Alan Varela, Director

February 5, 2025

**Re: Twilight Homes at Montage Unit 5 at MDS (Block 3 Lots 14-24 and 29-33 only)  
Erosion and Sediment Control Plan  
Engineer's Stamp Date 2/3/2025 (R16E006C\_T)**

Based on the information in your submittal received on 1/15/25, the ESC Plan can't be approved until the following comments are addressed.

Lot Number

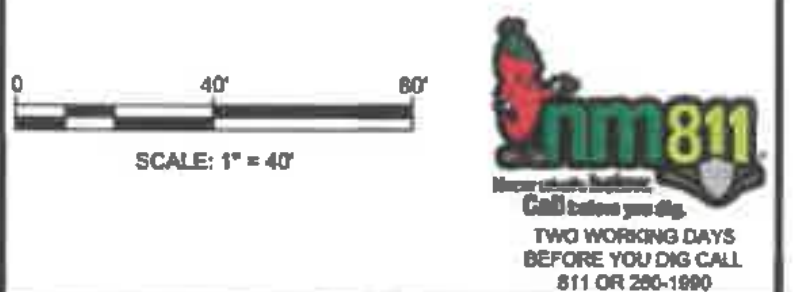
4. Include the lot and block numbers of every lot covered by the ESC Plan in the Title of the ESC Plan and on the SWQ Info Sheet.
5. Street names are missing from the adjacent streets on the ESC Plan. Label all street names on the map.

6. Block numbers are missing from the map. Label lot and block numbers on the map. Include lot and block numbers of adjacent lots also.
7. Parimeter controls are missing on portions of all of the lots. Parimeter controls are required adjacent to all streets, allies, and HOA landscape tracts, and may consist of either Curb Cutback swales or Silt Fence. Curb Cutbacks are acceptable on all types of curbs including role curb, however they are not allowed where the sidewalk has already been constructed.

8. Street and alley longitudinal slopes are required on all G&D Plans and ESC Plans, so where slopes were omitted they must be added on the ESC Plan. Check dams or silt fences are required at each side lot line next to the parimeter controls where street slopes exceed 2.5%.
